**WRITTEN REPRESENTATIONS OF THE HISTORIC BUILDINGS AND MONUMENTS  
COMMISSION FOR ENGLAND (HISTORIC ENGLAND)**

**FOR AN ORDER GRANTING DEVELOPMENT CONSENT FOR THE: BOTLEY WEST  
SOLAR FARM**

**APPLICATION REF: EN010147**

**DEADLINE 2 SUBMISSION: 4<sup>TH</sup> JUNE 2025**

Photovoltaic Development Partners GmbH
 Kurfürstendamm 52
 10707 Berlin, Germany

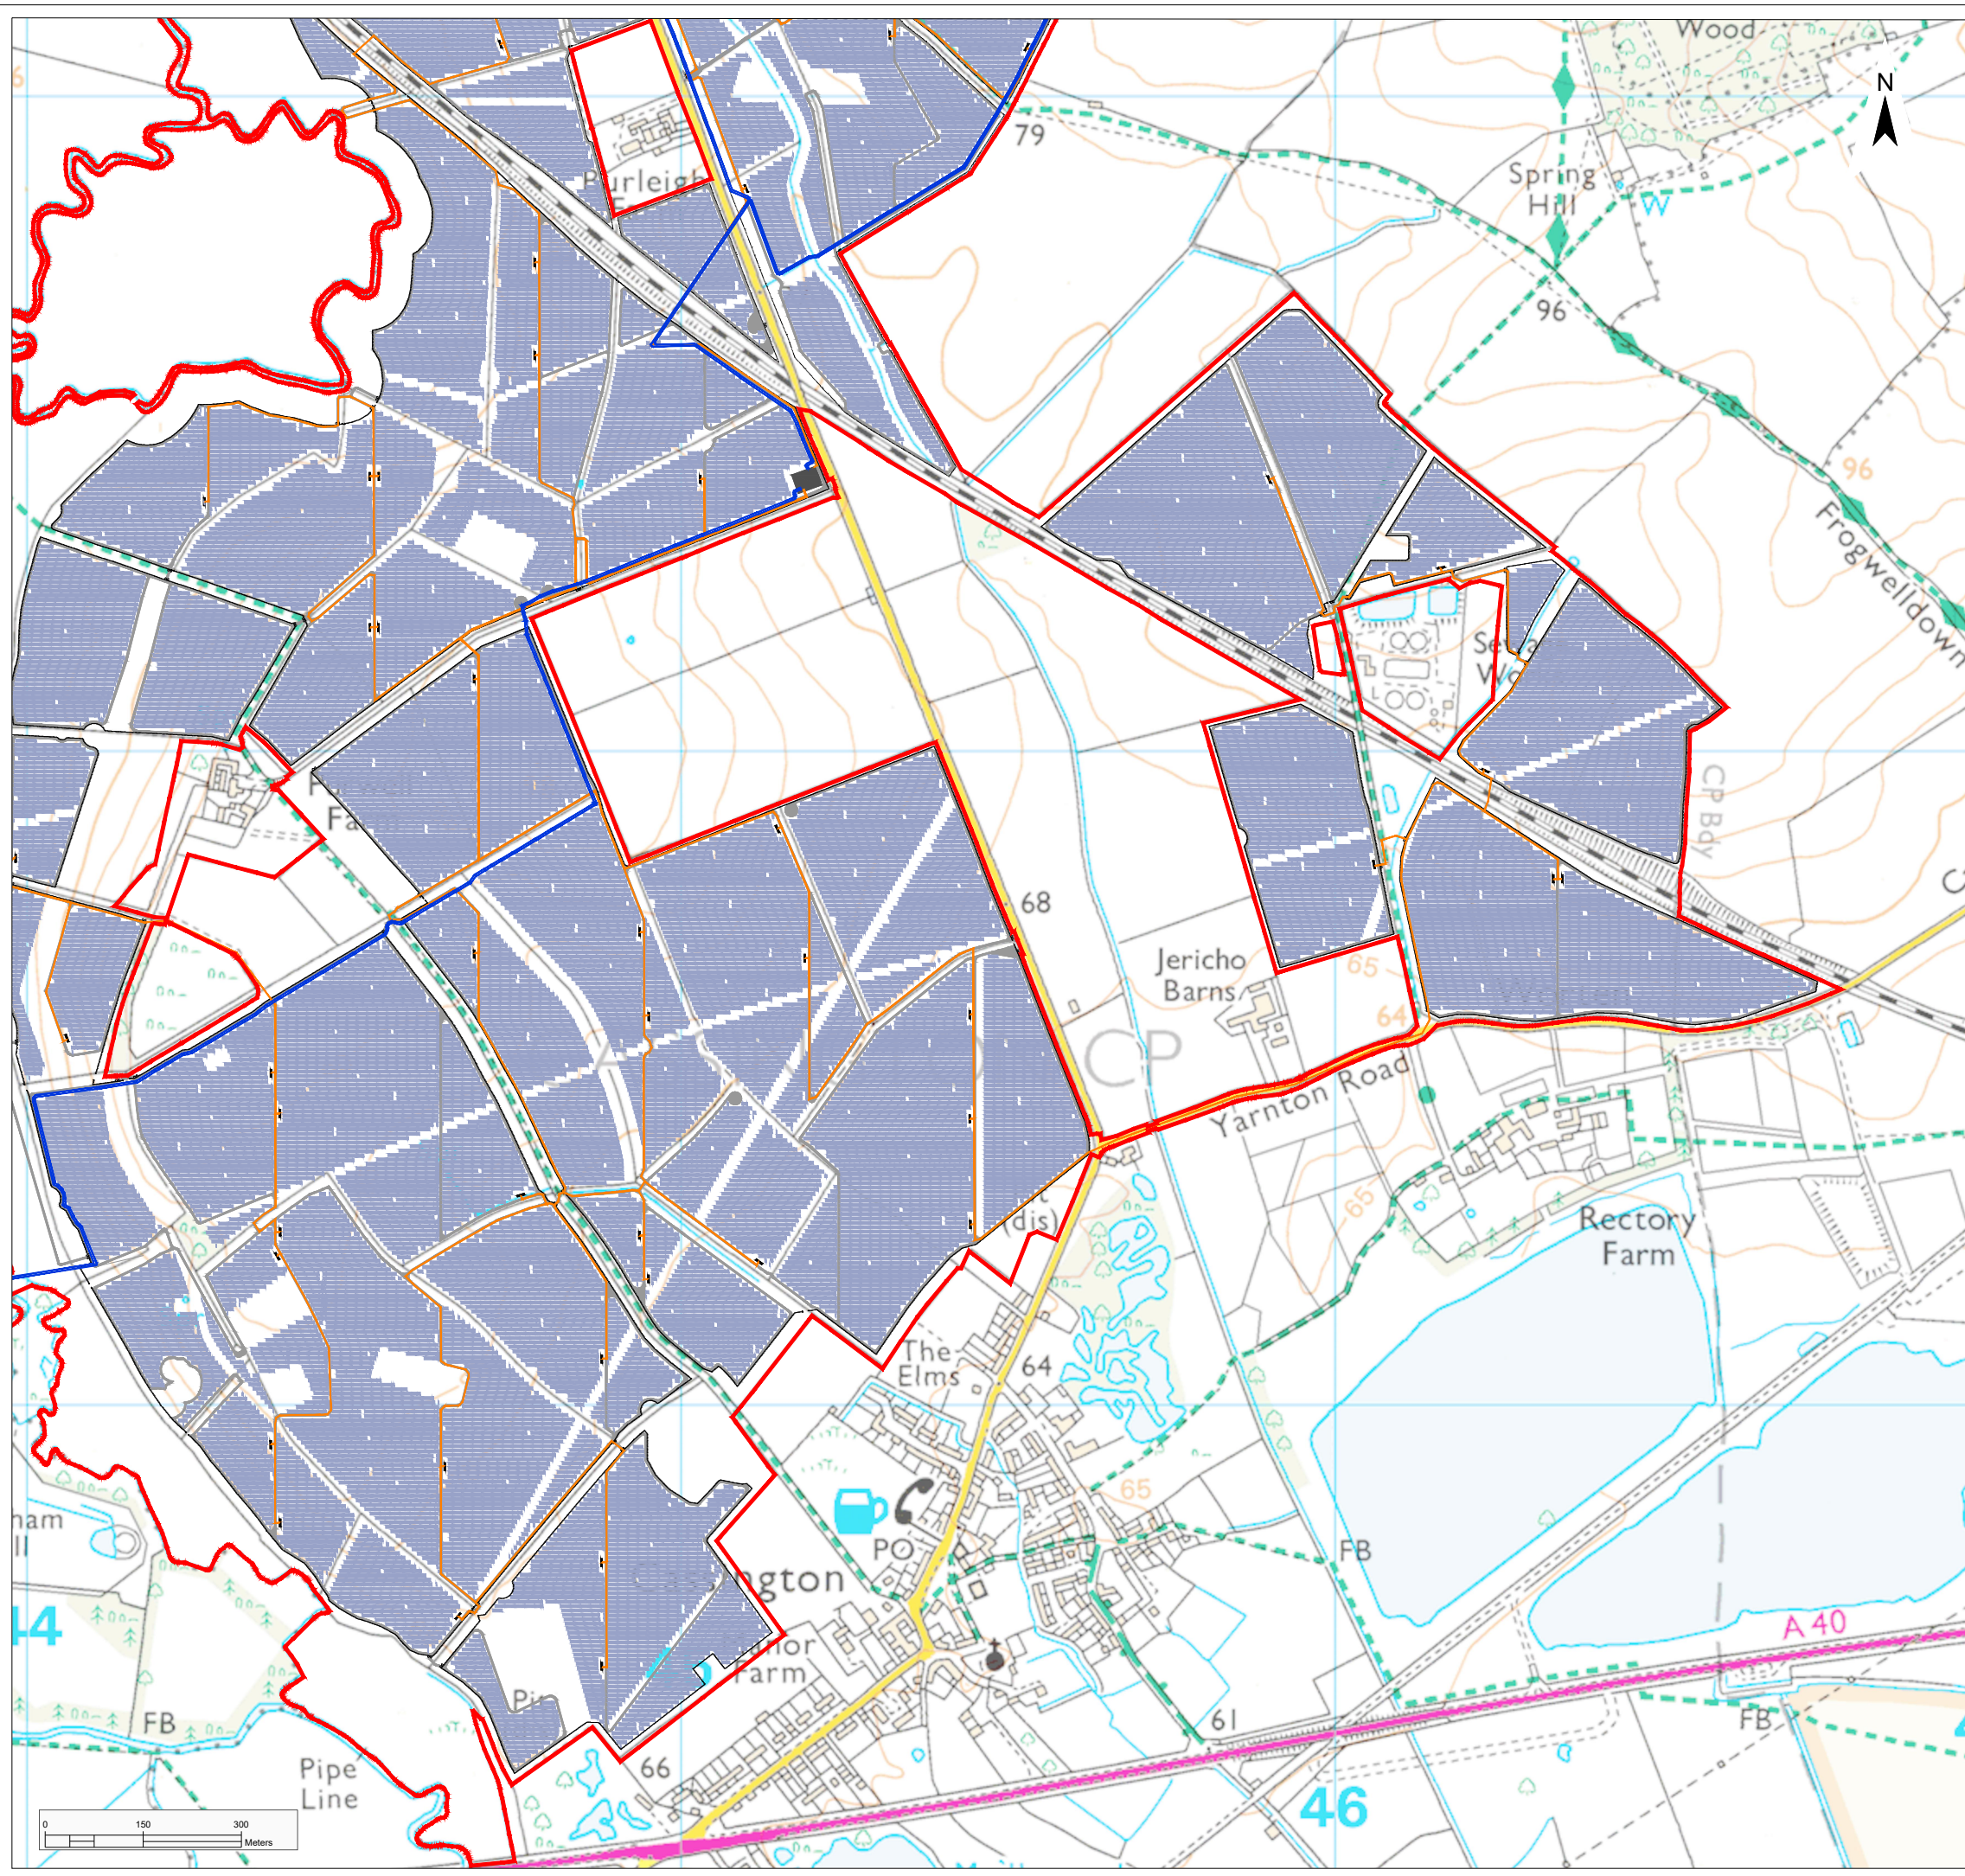
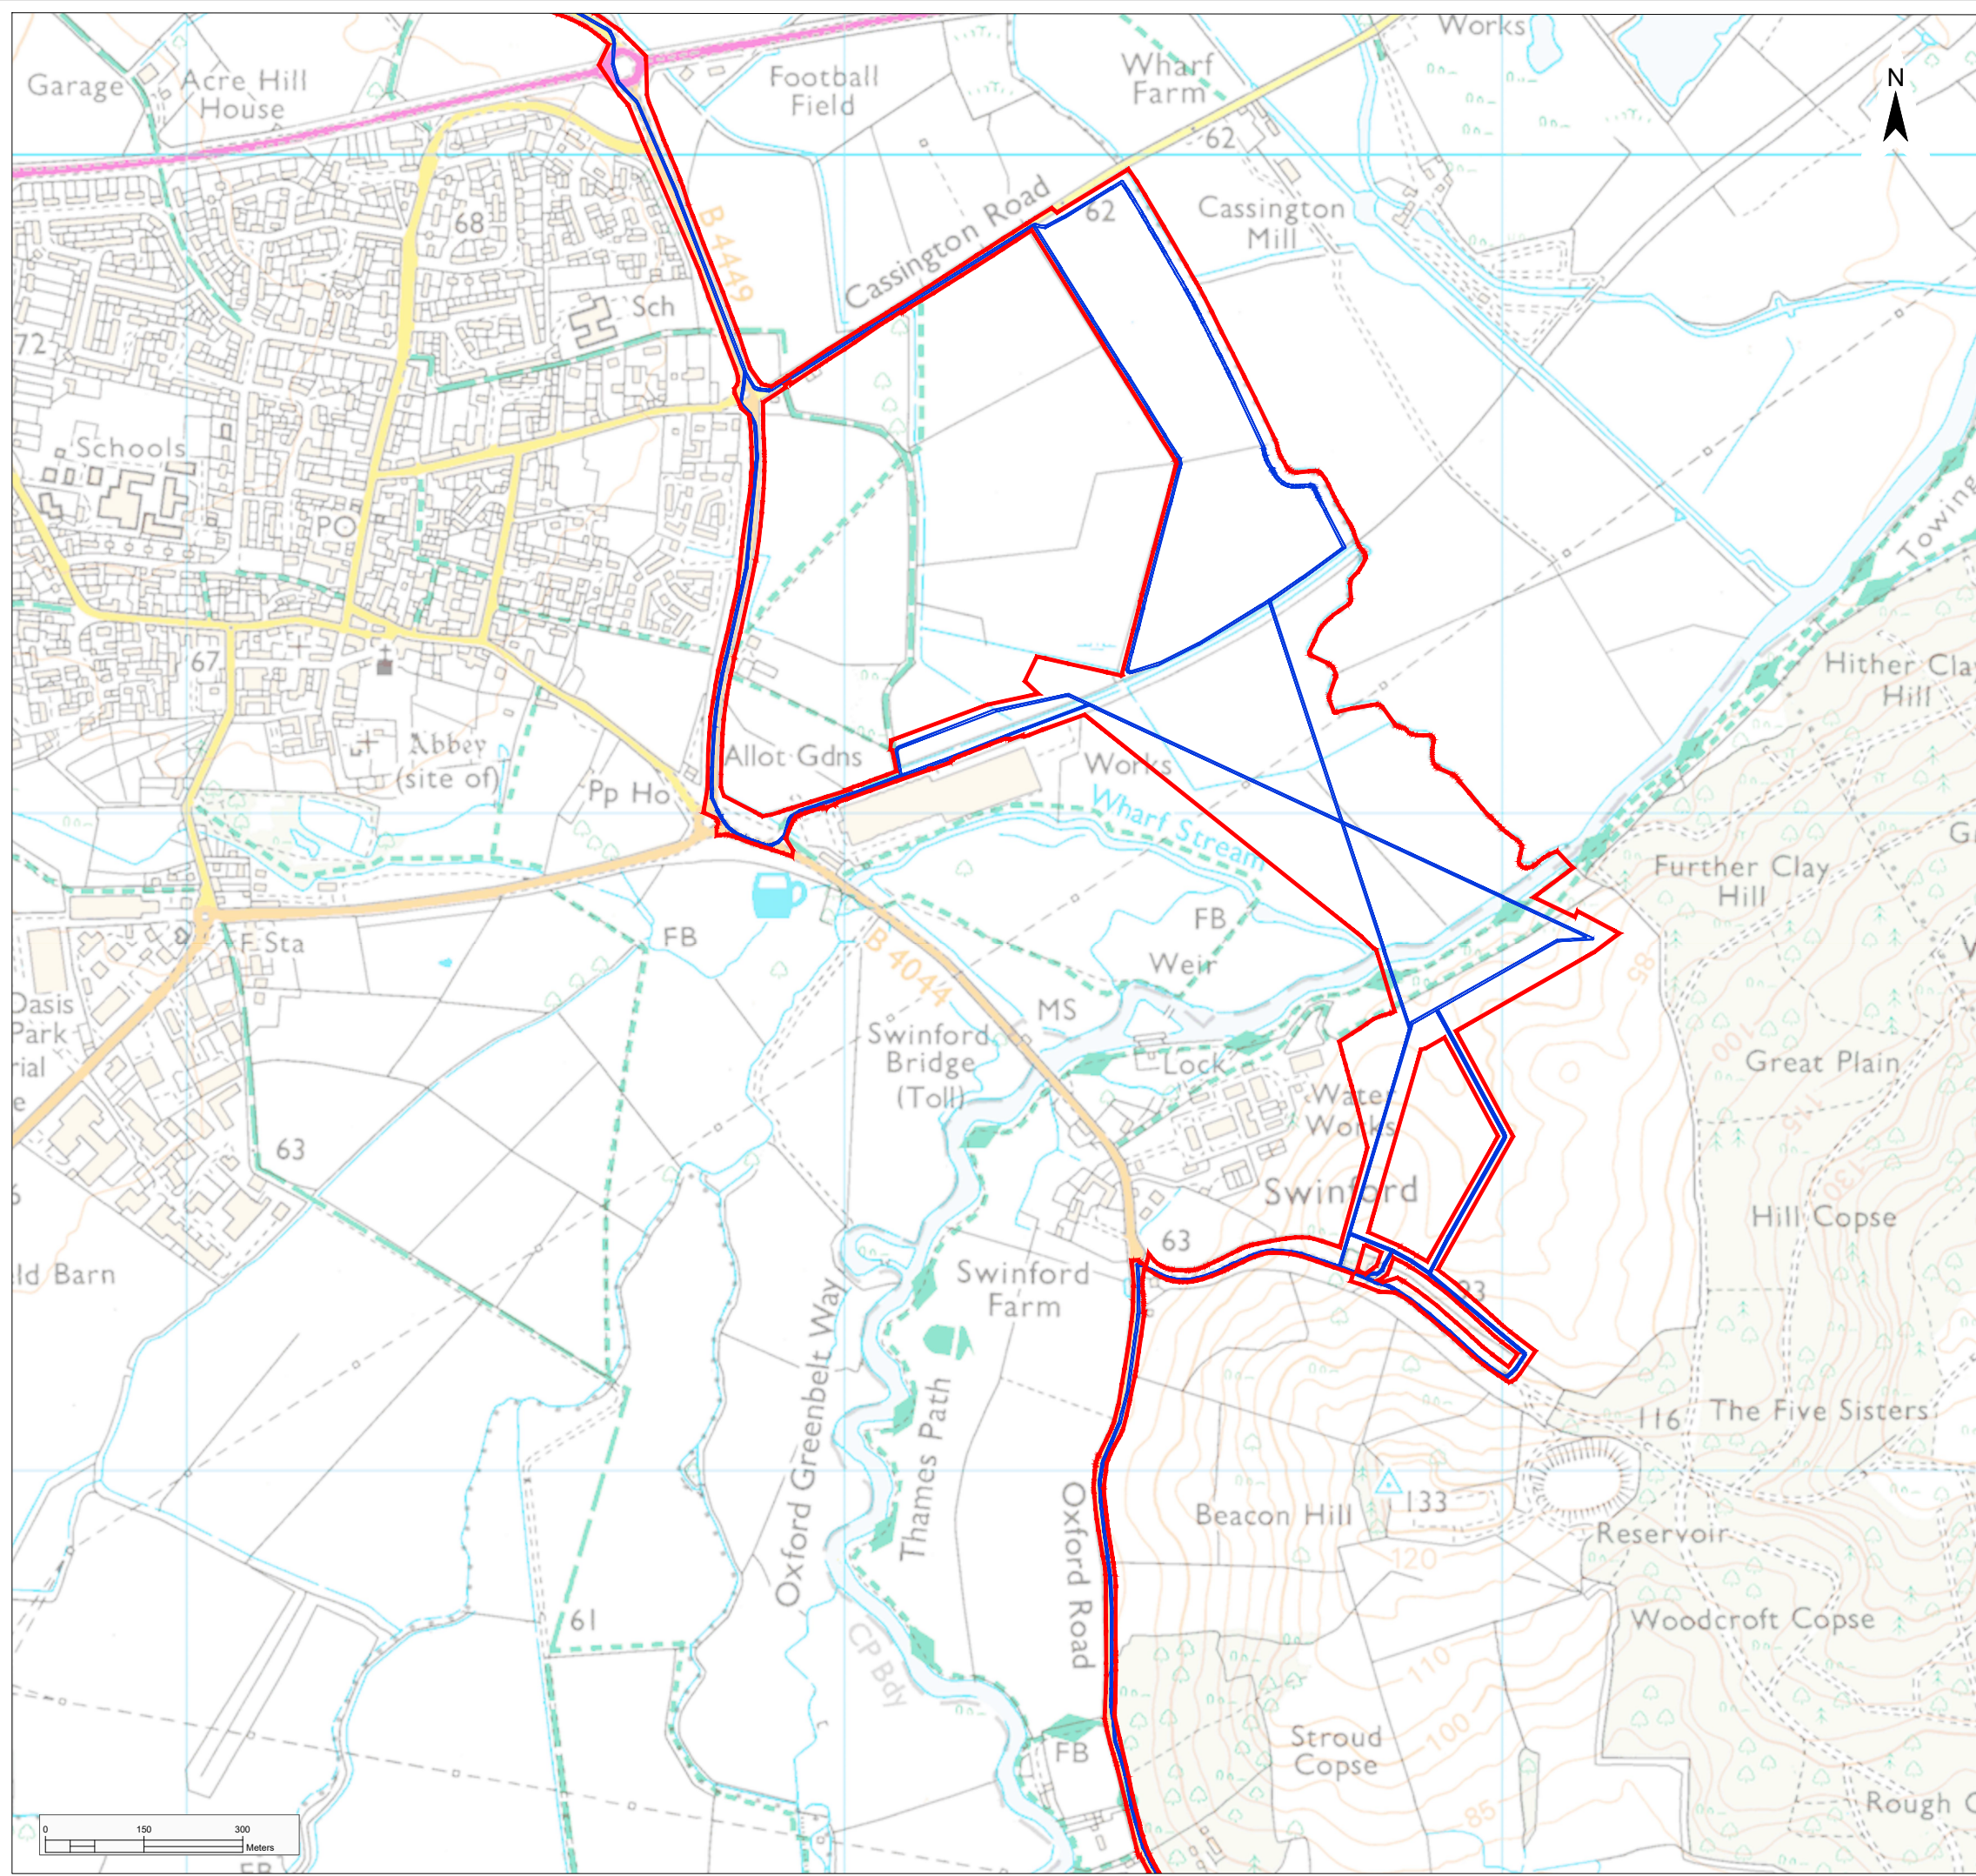
- 3.4. Historic England has made its own assessment of the contribution the application site makes to the significance and OUV of Blenheim Palace World Heritage Site (WHS). On this basis we have identified areas where we consider panels would cause harm to this internationally recognised and important site and should be removed to avoid harmful impacts.
-

3.5. We considered that whilst the majority of the scheme would not harm the OUV of the WHS, land parcels 2.1, 2.2, 2.5 and 2.20-2.26 of the central section of the Botley West Solar Farm would do so. This is because these land parcels do contribute to the maintenance of Blenheim's OUV as these fields are locations in which the Blenheim ensemble can be appreciated from open countryside. Solar array development in these fields would therefore detract from the contribution made by the setting of Blenheim, in a way that would harm its Outstanding Universal Value. We therefore recommended the removal of panels from these parcels.
